DRB Application No.: 10DRB-70316 Project # 1008575
 Project Name: WASHINGTON BUSINESS PARK
 Agent: DWL ARCHITECTS Phone No.: 242-6202 (Peter Siebert)

Project# 1008575

10DRB-70316 MAJOR – SITE DEVELOPMENT PLAN FOR BUILDING PERMIT

Re: Landfill Gas Mitigation Report for H.B. Warehouse
8405 Washington Place, NE

SHEET TITLE:
SITE DEVELOPMENT PLAN

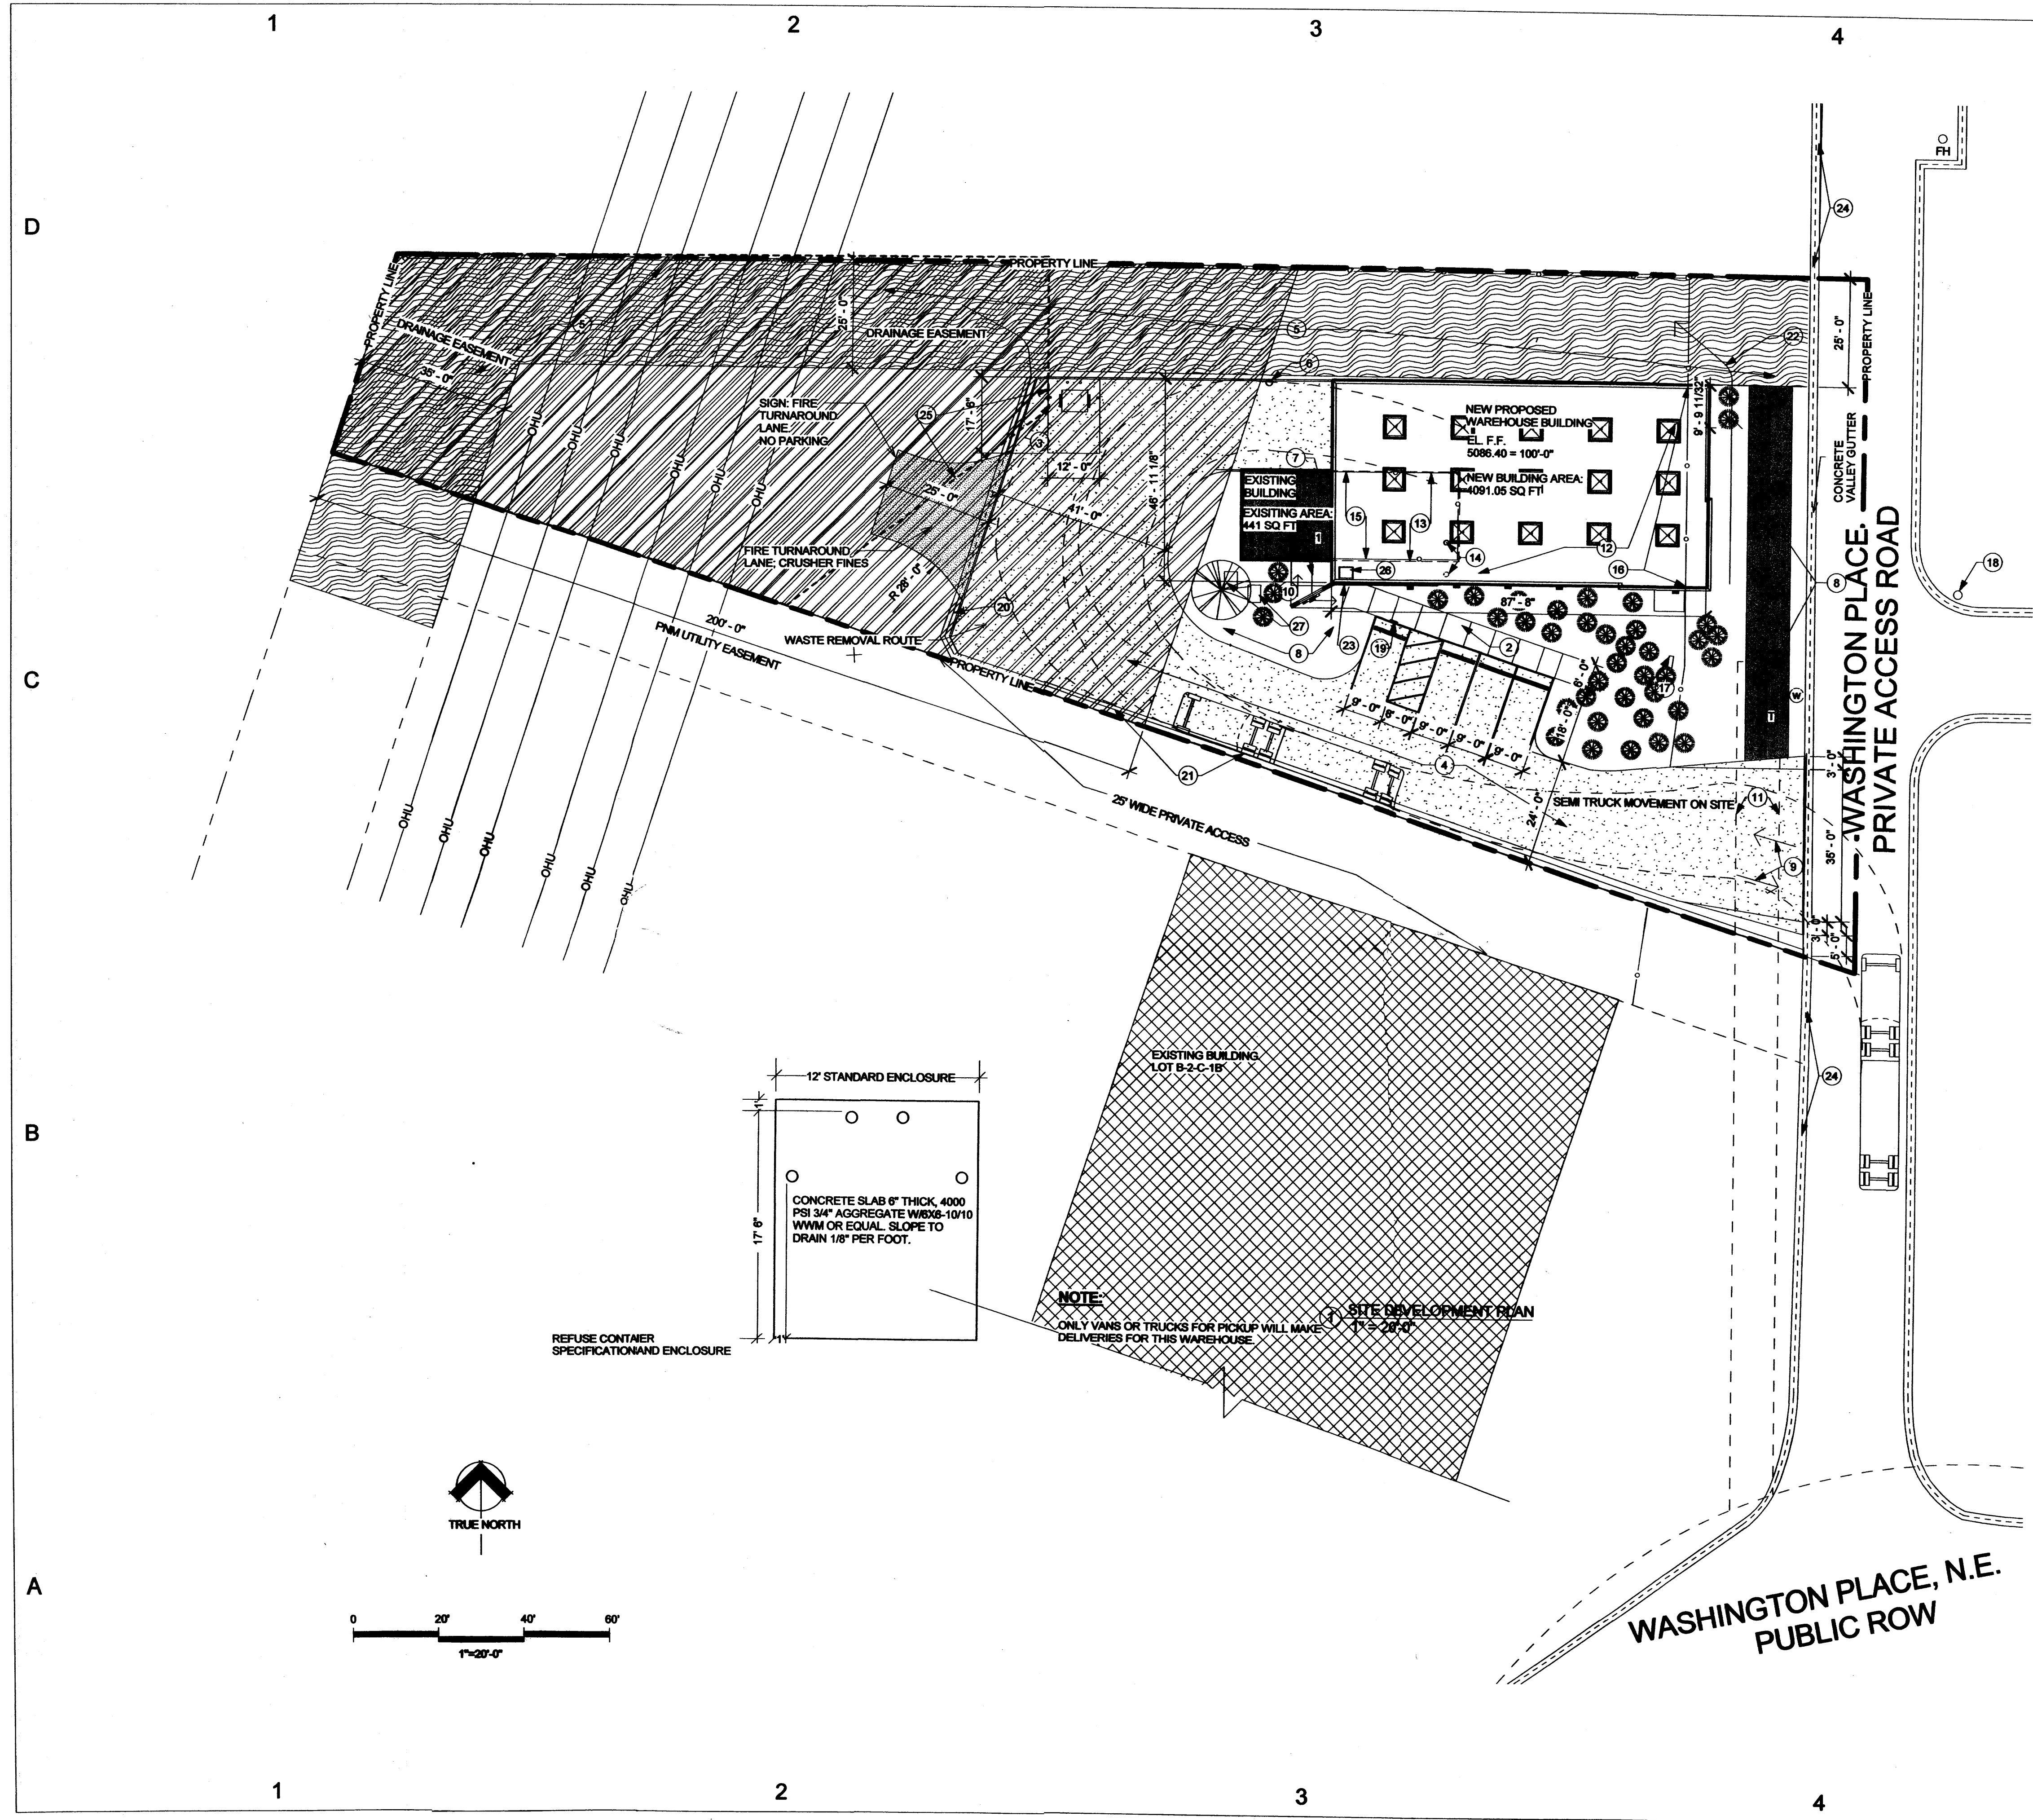
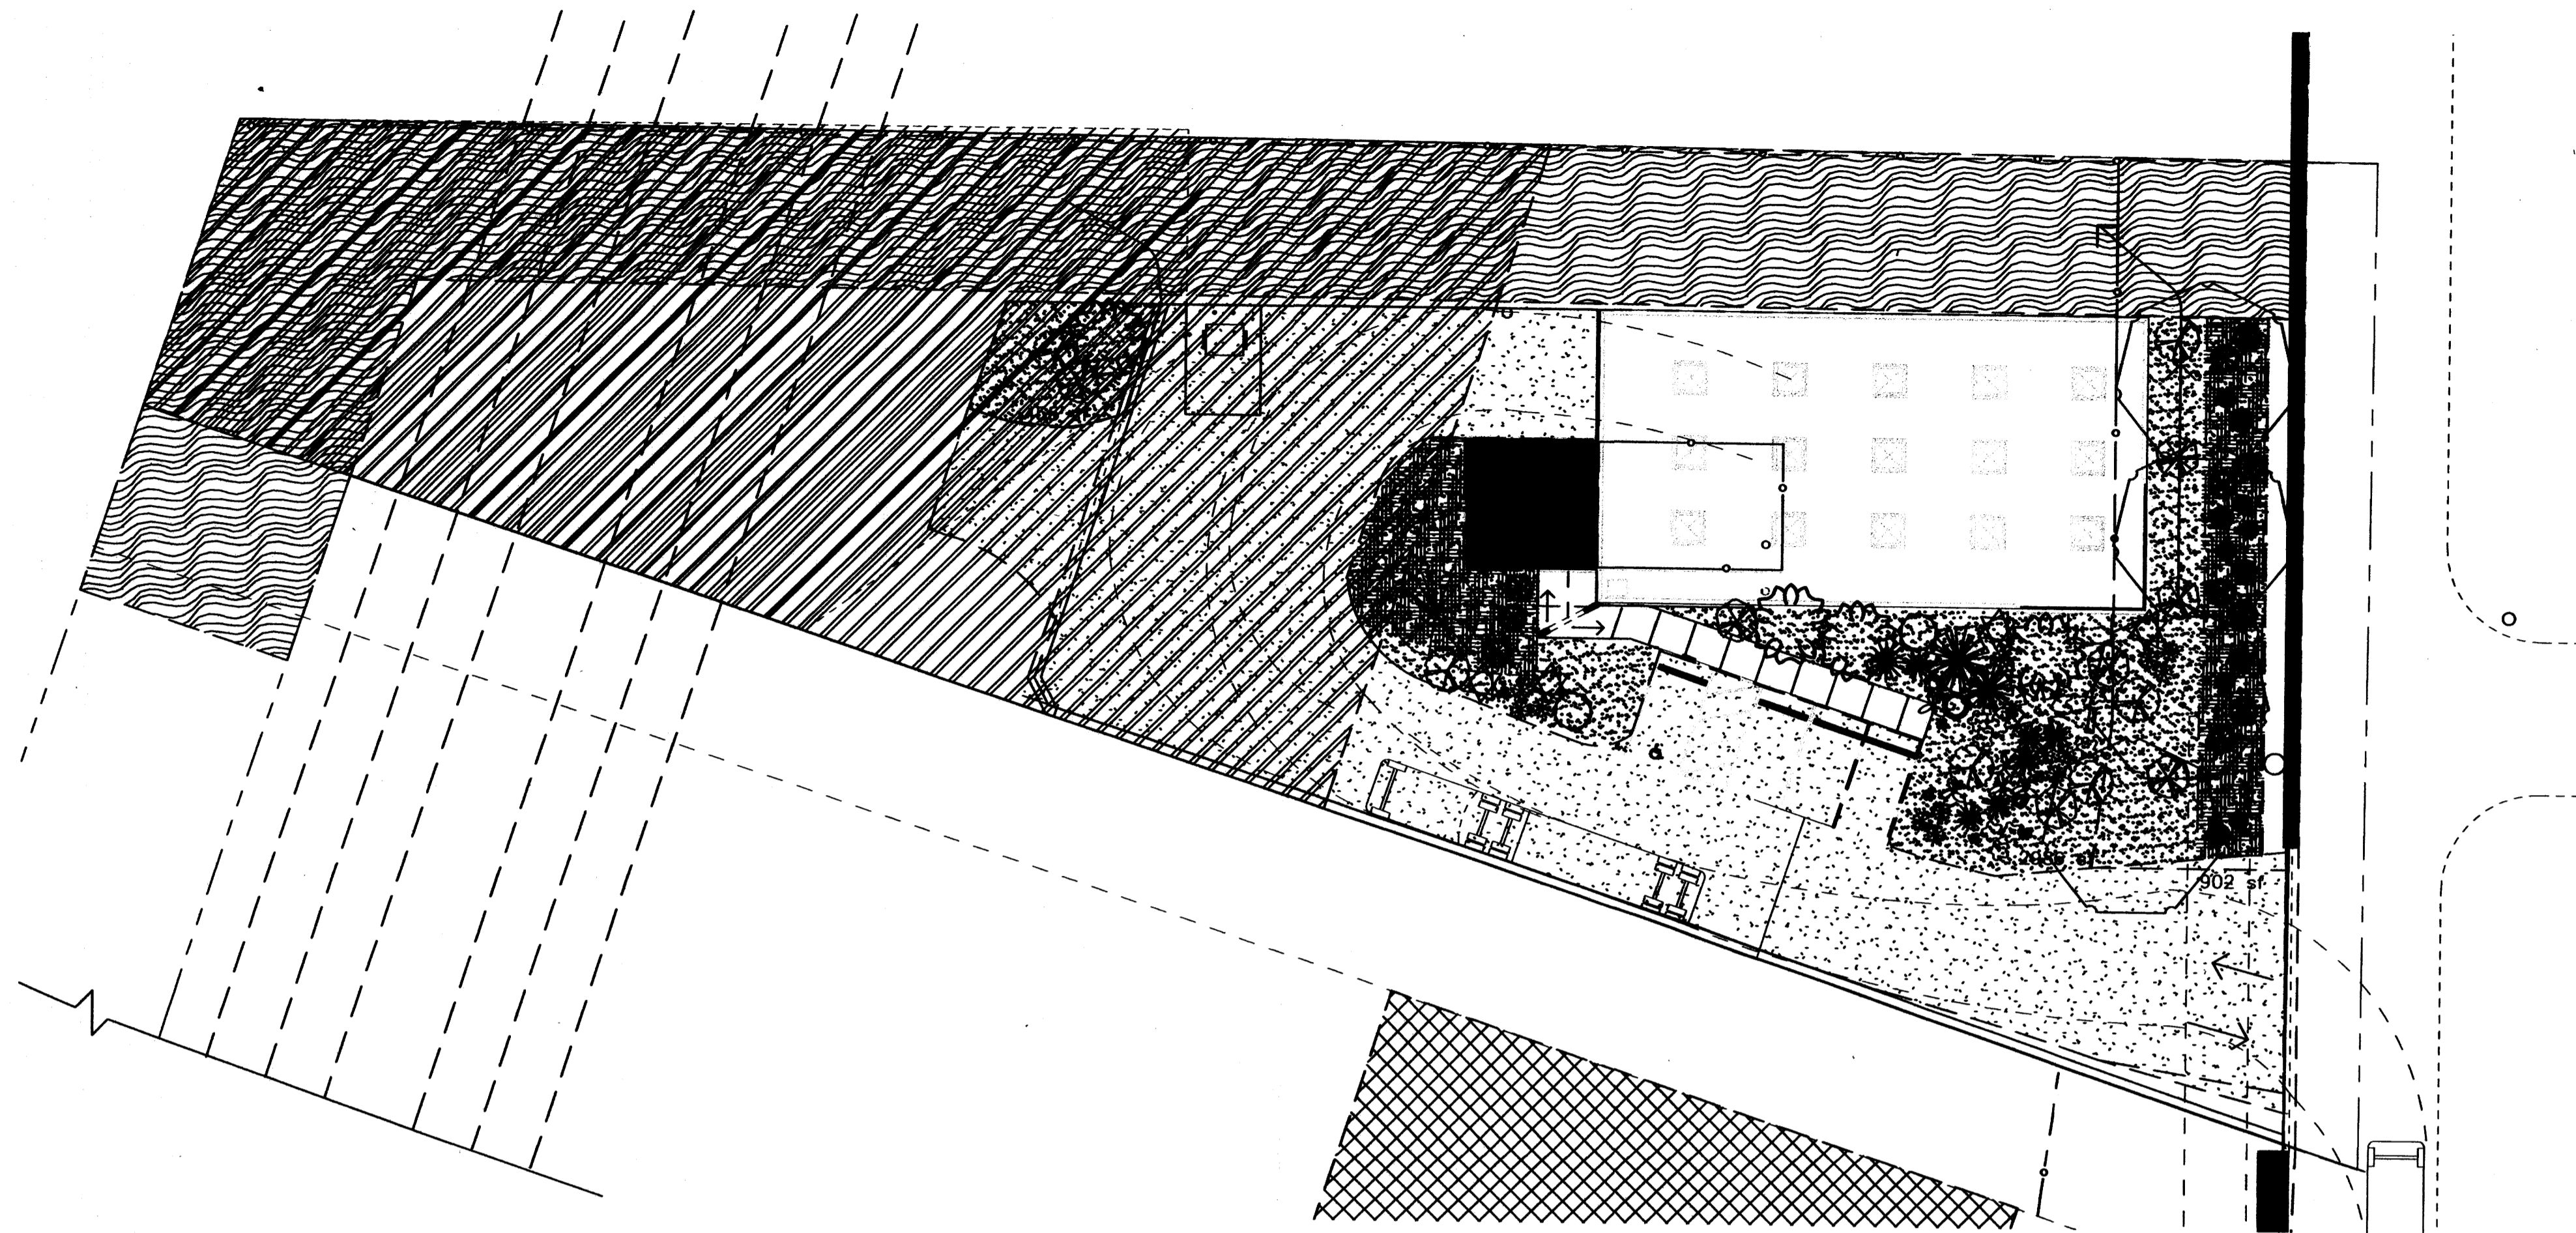
Provide an exhibit showing the location of sidewalk and defining the distance from face of curb to the property line. Right of way dedication may be required.
Two different plans are labeled "Site Plan." Please clarify.
The plan is difficult to read with the overlapping hatching.
A 6-foot wide, ADA accessible, pedestrian pathway is required from the street to the building.
Provide a ramp detail. Define the maximum slope.
Is Washington Place a private roadway? Please clarify.
Clarify existing versus proposed conditions.
A 25-foot wide private access is shown adjacent to the lot. Provide a copy of this easement. Who are the beneficiaries of this easement?
Define all hatching shown on the plan.
Is the concrete valley gutter existing?
Show the nearest drive on the adjacent lot.

Please provide a Zome Map Atlas page reference on site plan.
Additional information is needed on main access and adjacent 25' Private Access; please provide a copy of the latest plat for the DRB file and refer to comments from Transportation Development, particularly regarding proximity of driveways.
Overlay of hatch patterns is not readable – PNM and DRAINAGE EASEMENTS need to be shown with different line patterns instead. The Landscape Plan has a hatch pattern that does not appear in the legend.
Chain link fence is not acceptable (Keyed Note 13). Refer to comments from Zoning Enforcement regarding compliance with Zoning Code and North I-25 Sector Plan.

1. The provided Site Development Plan for DRB does not include any of the recommended mitigation measures.
2. The provided Site Development Plan does not contain the Landfill Gas Disclosure Statement on the cover sheet.
3. A Letter of Commitment to construct, operate and maintain the landfill gas mitigation measures is required prior to approval of the Site Development Plan.
